***RE: Grading and Drainage Certification for Desert Flower Subdivision Unit Four,
(M10/D12D), Engineer's Certification Stamp Dated 2/9/99.***

***RE: Revised Grading and Drainage Plan for Desert Flower Subdivision, Unit Four,
(M10/D12D) Submitted for Final Plat and Work Order Approval, Engineer's Stamp
Dated 9/22/98.***

RE: Drainage Report for Desert Flower Subdivision, Unit Four, Dated 9/1/98, and Grading and Drainage Plan, Dated 8/31/98, (M10/D12D) Submitted for Preliminary and Final Plat and Work Order Approval.

DRAINAGE REPORT
FOR
DESERT FLOWER SUBDIVISION
UNIT FOUR

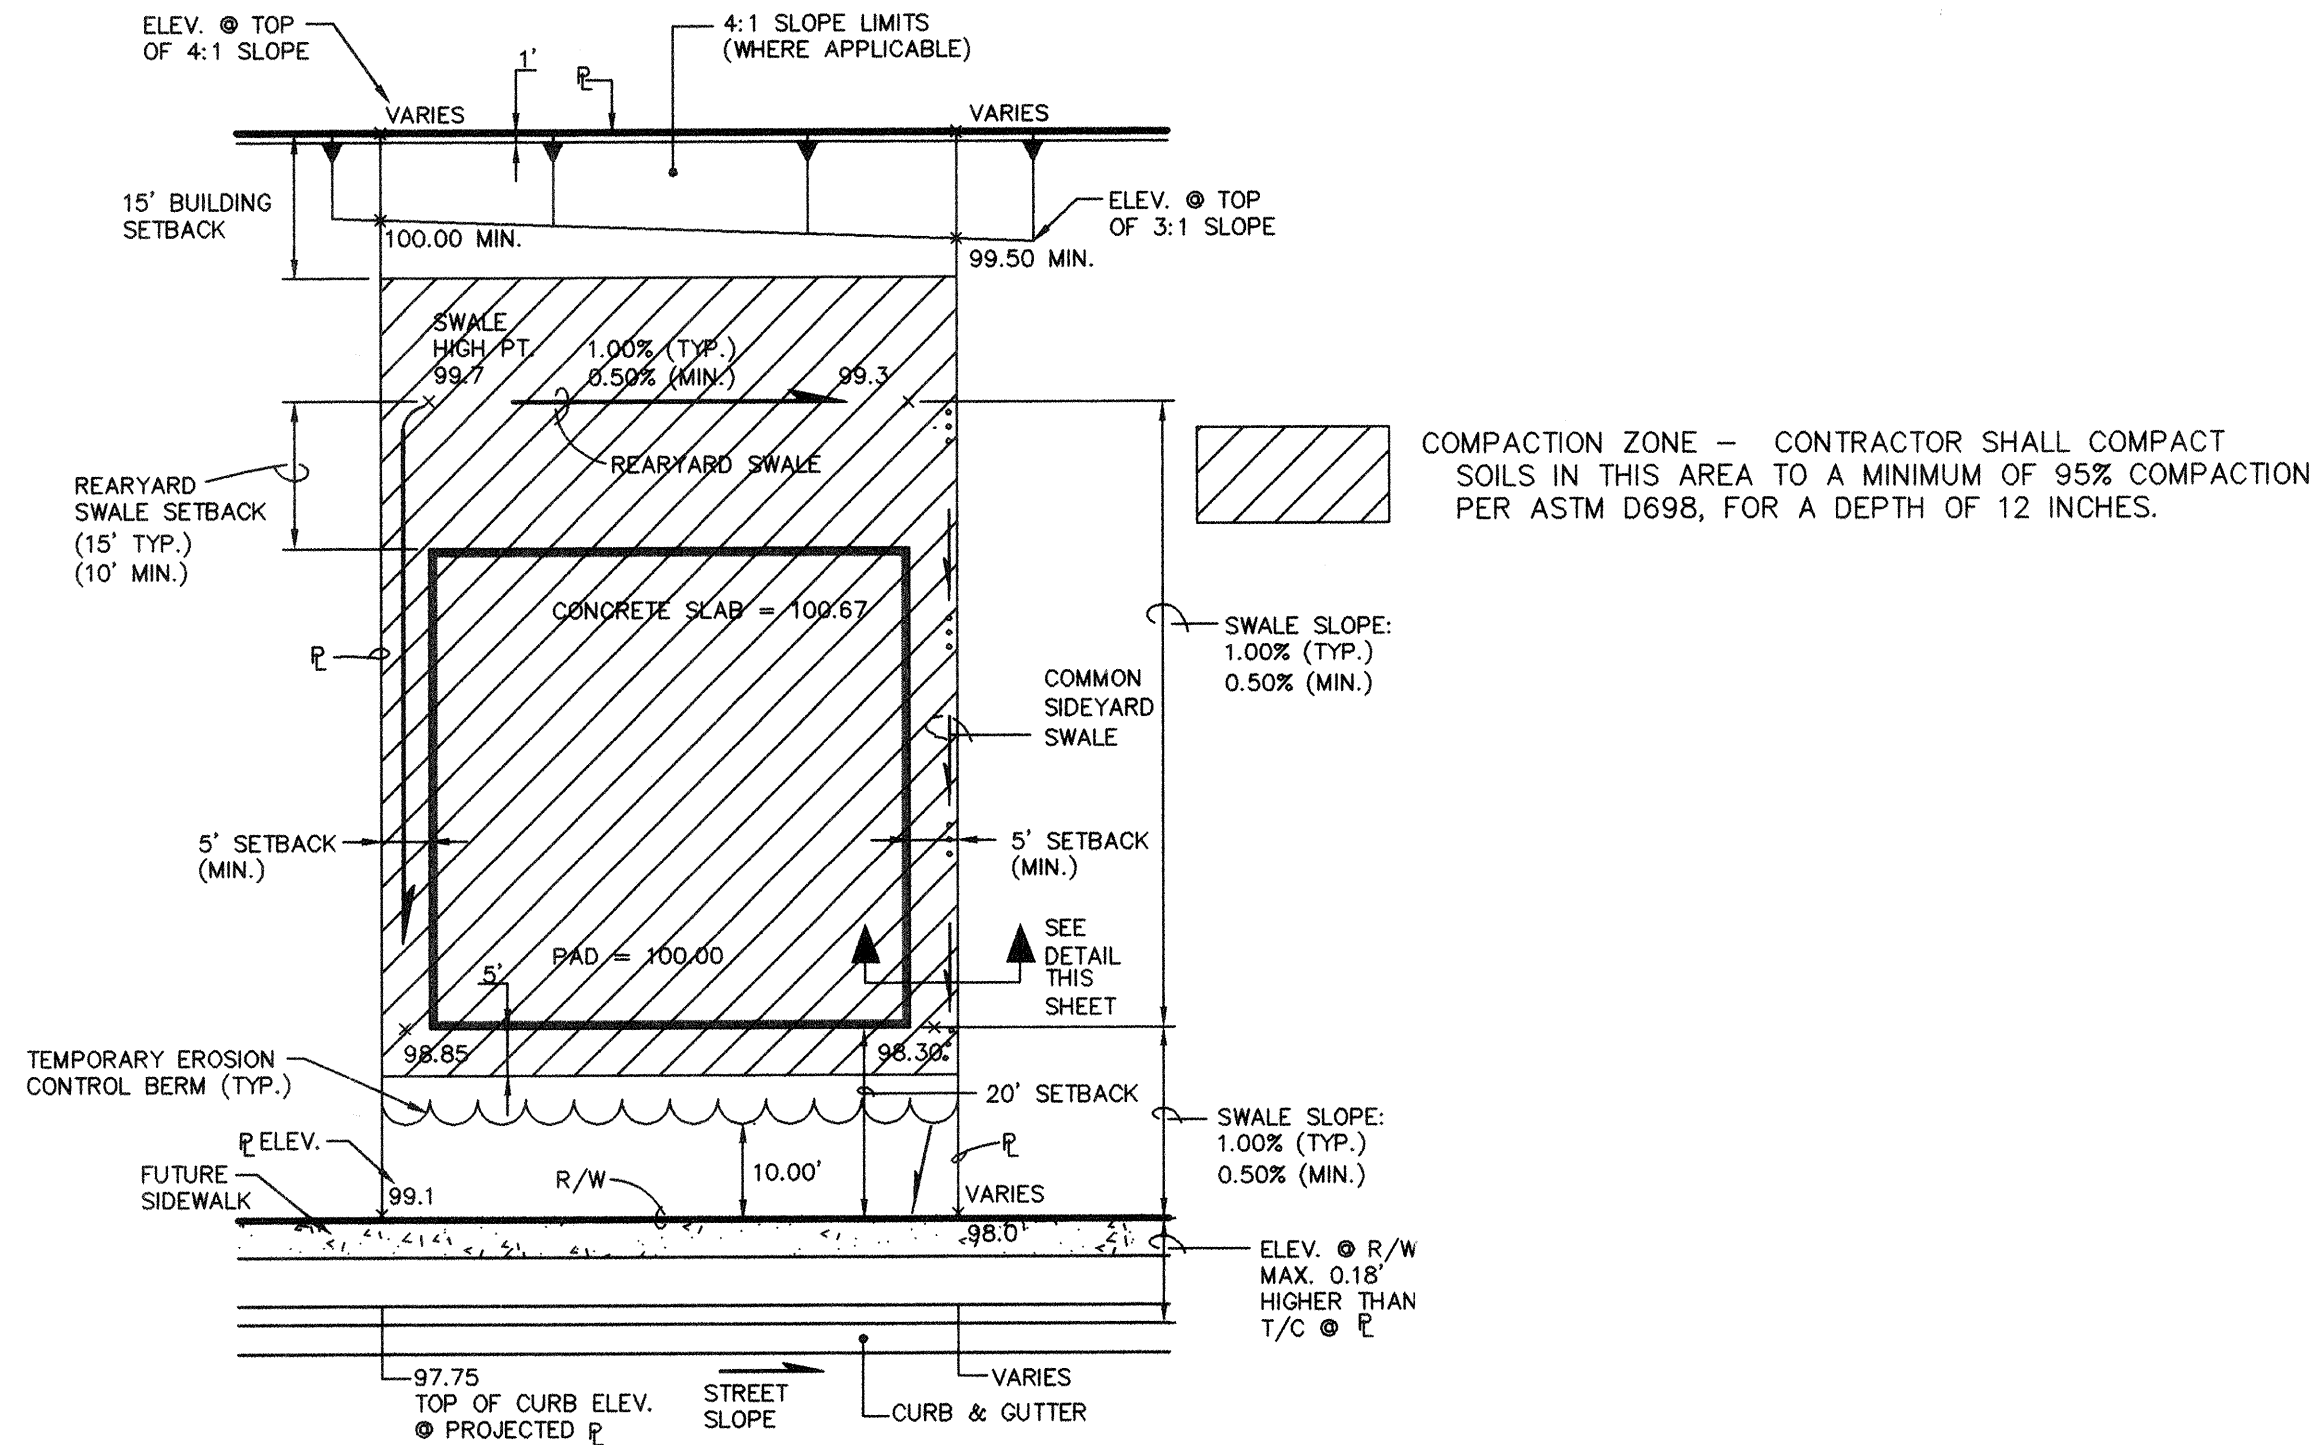
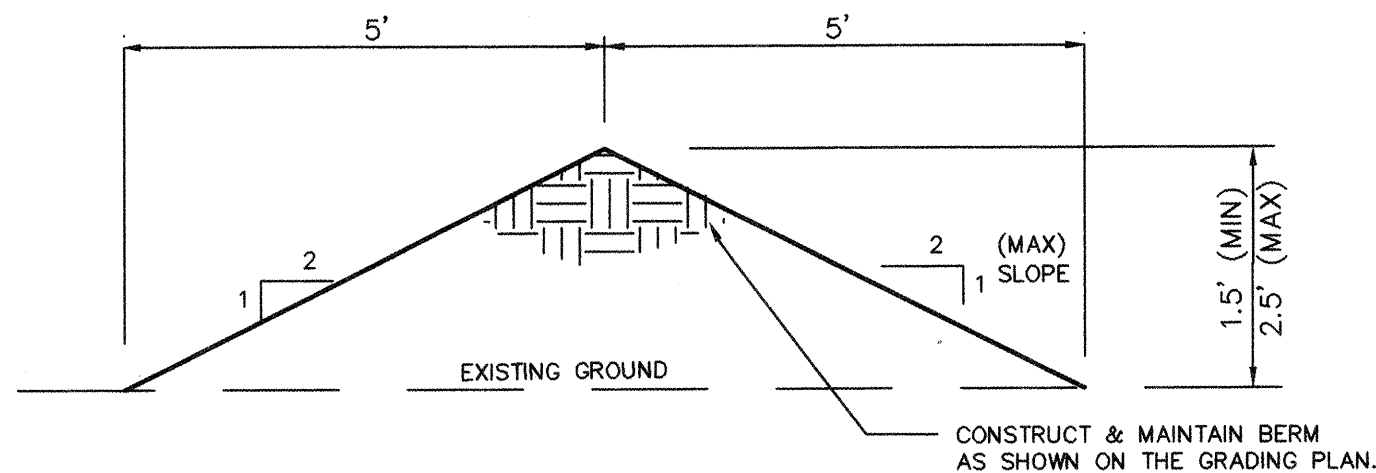
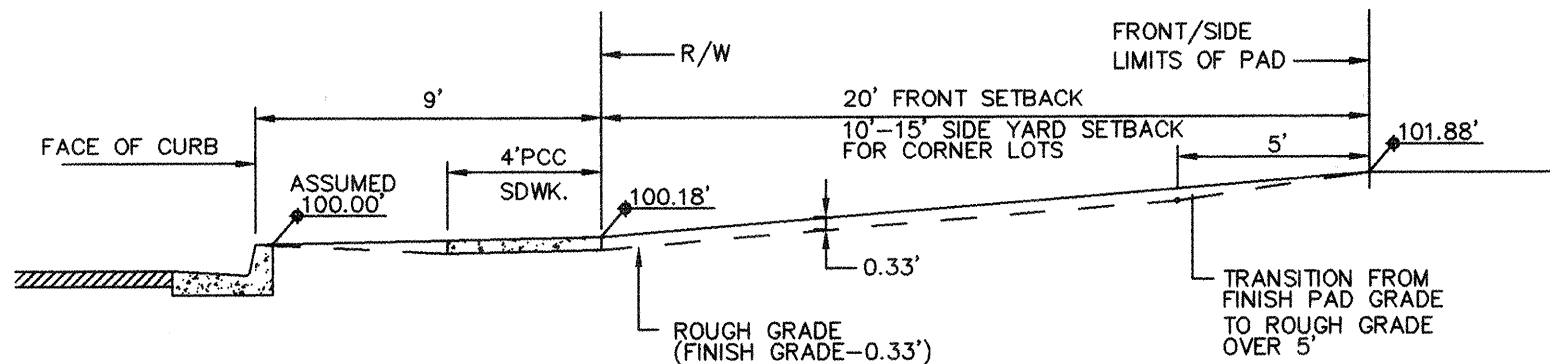
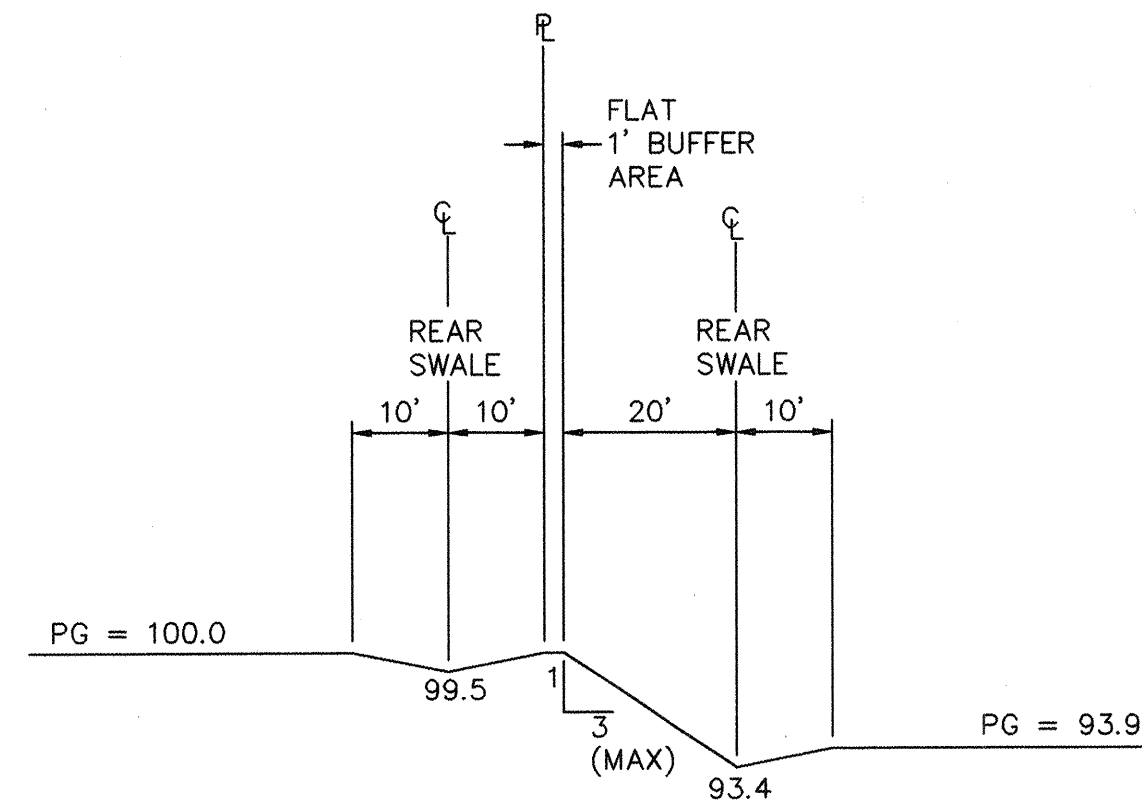
If this Unit is to be divided into Units 4A and 4B, however, then the plan dated September 22, 1998 will have to be updated to show the temporary grading on 4B at the Unit boundary. It appears that the Unit boundary cuts through Lots 13 and 14 on the south side of Spring Flower Road. This must also be addressed.

Remarks: Susan - As we discussed earlier, I
have attached a copy of the approved
grading & drainage plan with the temporary
rundown shifted away from the new SAS
line for your files. If you have any questions
By: Melissa Combs Copies To please call.
